**Highways England: A303 Amesbury to Berwick Down Project, Development Consent Order
Application Scheme Ref: TR010025**

Comments on Highways England's Deadline 4 Submission REP4-036: 8.31 Comments on
any further information requested by the ExA and received to Deadline 3

Prepared by Dr. G.M. Reeves for the **Stonehenge Alliance Ref. 2001870**

PROPOSED BORED TUNNEL - (WORK No. 1F)

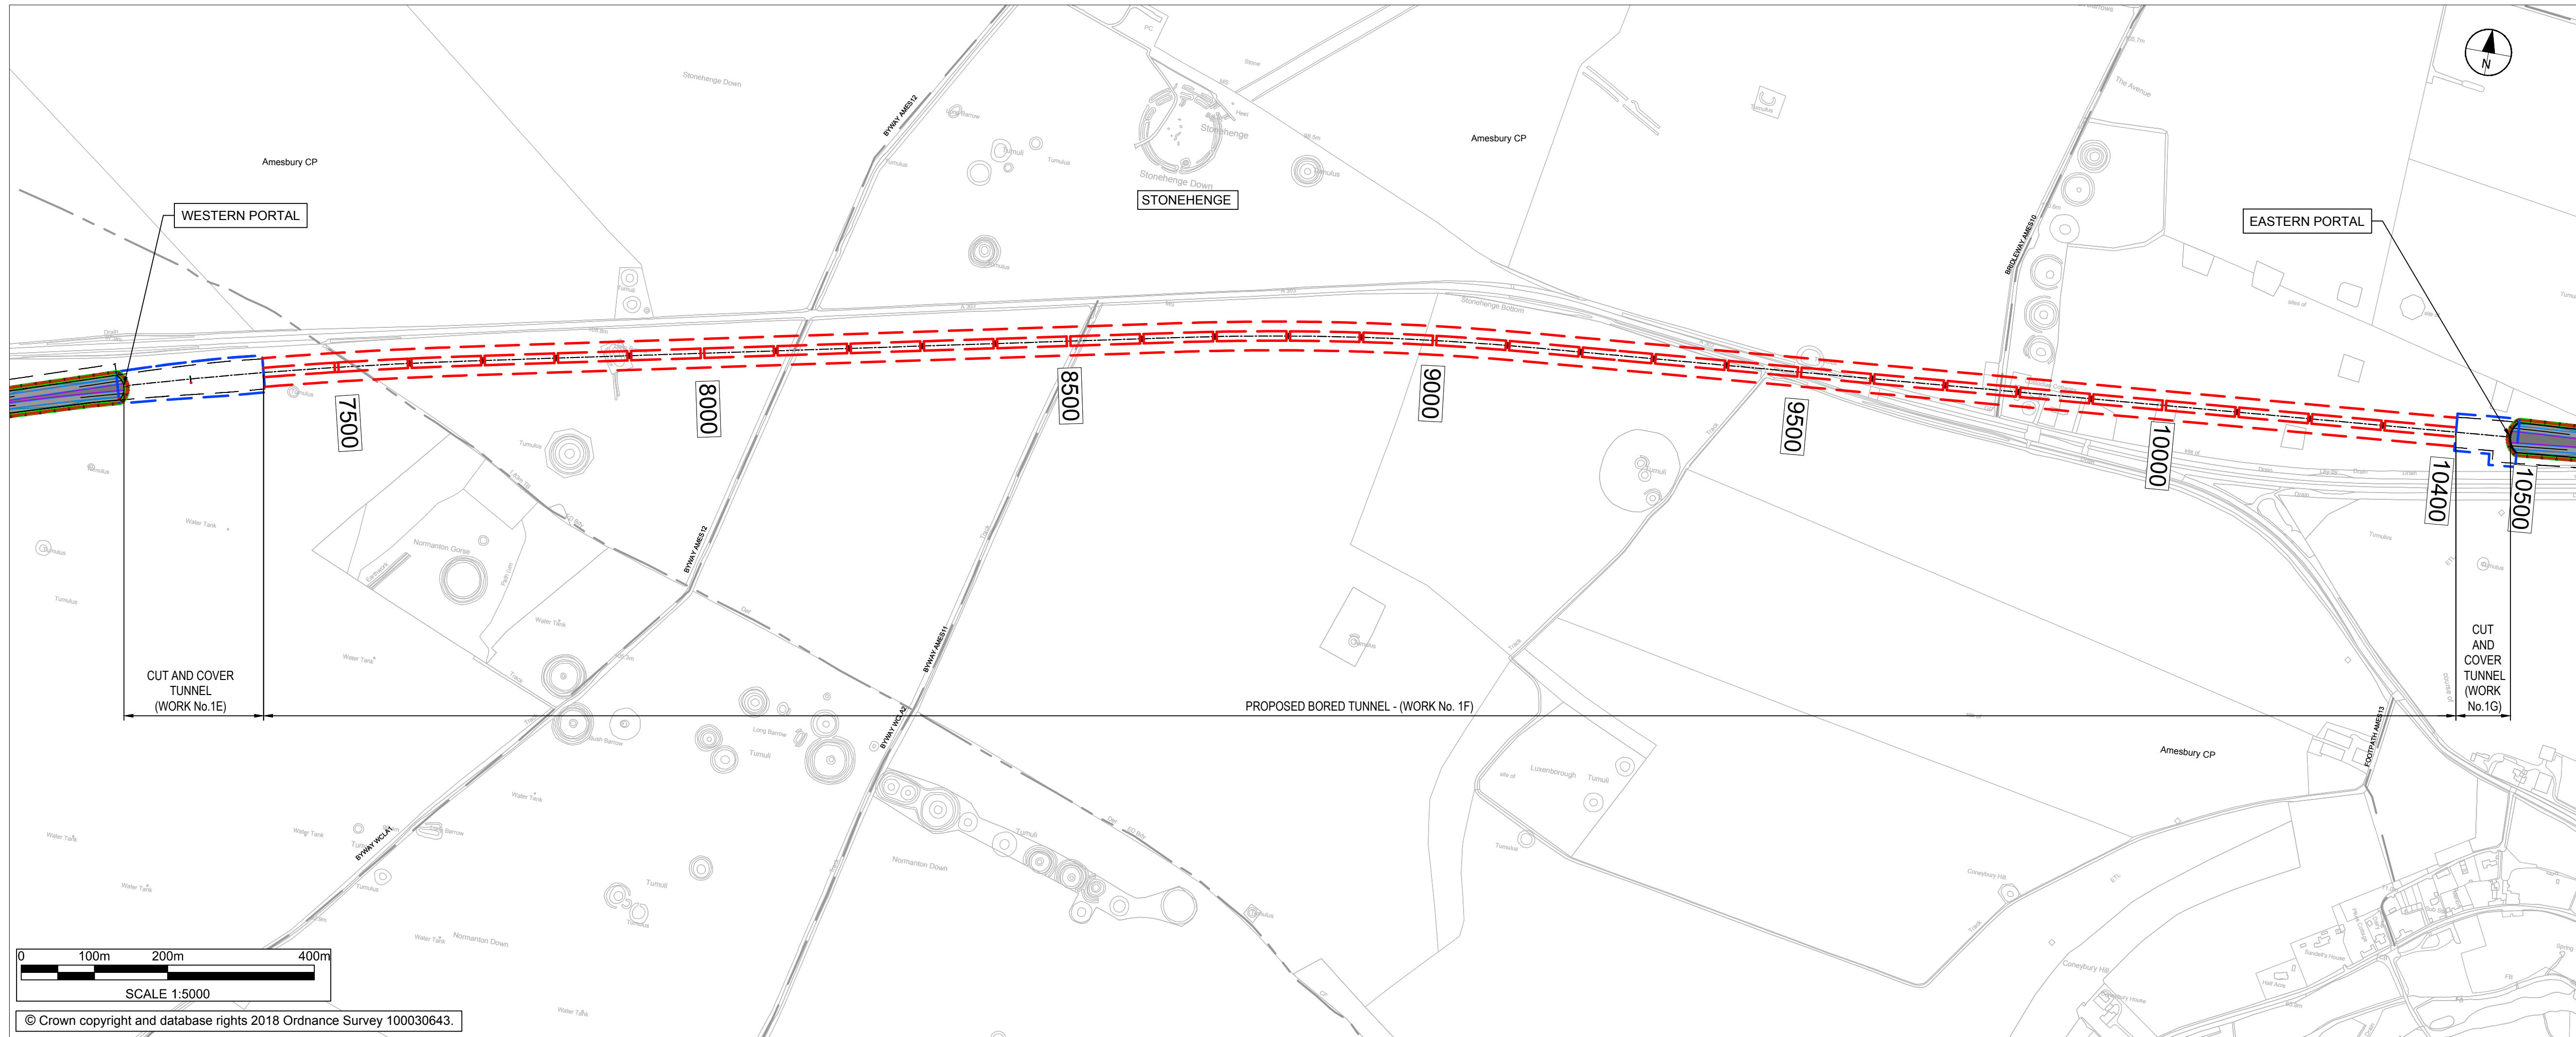
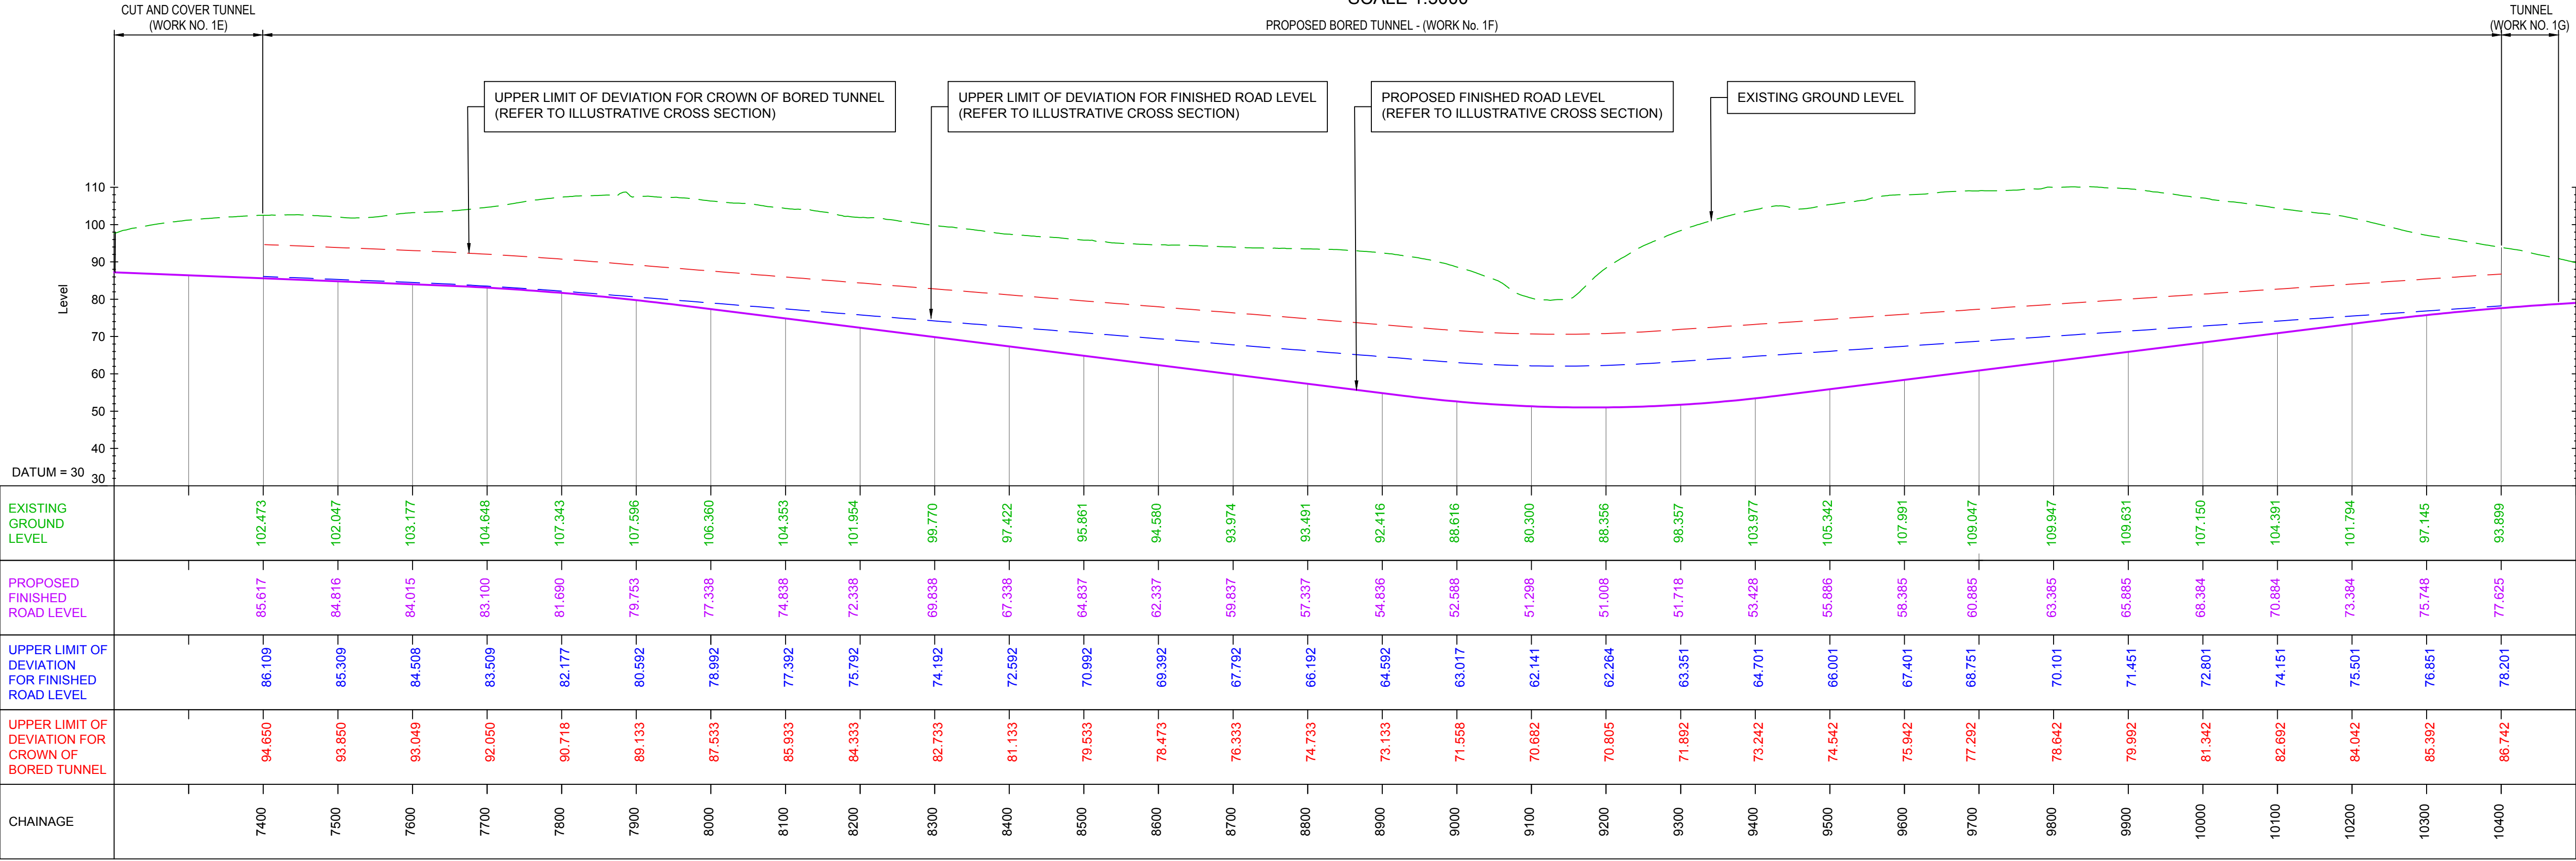
It is noted that Limits of Deviation to the vertical and lateral alignment of the tunnel are to be set by the DCO to allow for changes in the currently proposed design during detailed design by the contractor. The Bored Tunnel Limits of Deviation Plan (TR010025-2.16 Rev P02) submitted with the DCO application indicates an upper limit for the crown of the tunnel at 70 mAOD at the lowest point of the tunnel - beneath Stonehenge Bottom - and no lower limit to its vertical alignment. The groundwater risk assessment to date (most recently updated in Implications of 2018 Ground Investigations to the Groundwater Risk Assessment, P04. AECOM, Mace, WSP, April 2019) has assessed the impacts of an alignment where the crown, at its lowest point – beneath Stonehenge Bottom – is 55 mAOD. This assessment places the tunnel beneath the expected elevation of the Whitway Rock which acts as a preferential flow horizon (although the presence of these and exact location has not been confirmed to date). Due to the risk of the tunnel impeding flow along this horizon should its alignment, design or construction methodology change, it is essential that any changes to the detailed design are adequately risk assessed.

As of July 19th 2019, an inadequate understanding of present groundwater conditions exists along the proposed A303 road and Stonehenge tunnel route.

This poor level of detail is totally inappropriate and insufficient to investigate the complexity of groundwater movement, recharge, flow and discharges at the necessary scale and detail requirements of the 3.3km long tunnel.

The creation of any degree of groundwater barrier, as a result of tunnel construction, could affect local private abstractors, and even the discharge of the Blick Mead/Amesbury Abbey springs to the east.

There is therefore grave concern about long term effects due to potential changes in horizontal and vertical permeabilities of such zones as the Whitway Rock, the overlying Upper Seaford Chalk/Newhaven Beds, and fracture systems which control groundwater flow southwards below Stonehenge Bottom, respectively.

It is therefore essential that additional, deeper, targeted and cored borehole drilling is carried out, especially to the east of Stonehenge Bottom, as far as Countess Roundabout. This would enable proper investigation of geological and hydrogeological conditions at depth, below the proposed tunnel soffit level. Such boreholes would assess the presence or absence of the Whitway rock in the area of the Scheme and if present, its hydrogeological significance, especially in the eastern section of the Chalk that is likely to be affected by tunnel construction and operations.

The Applicant notes that a response to the theoretical presence of the Whitway Rock has been provided to the Environment Agency in the response to Written Representation 23.2.2-23.2.6 issued at deadline 3 [REP3-013].
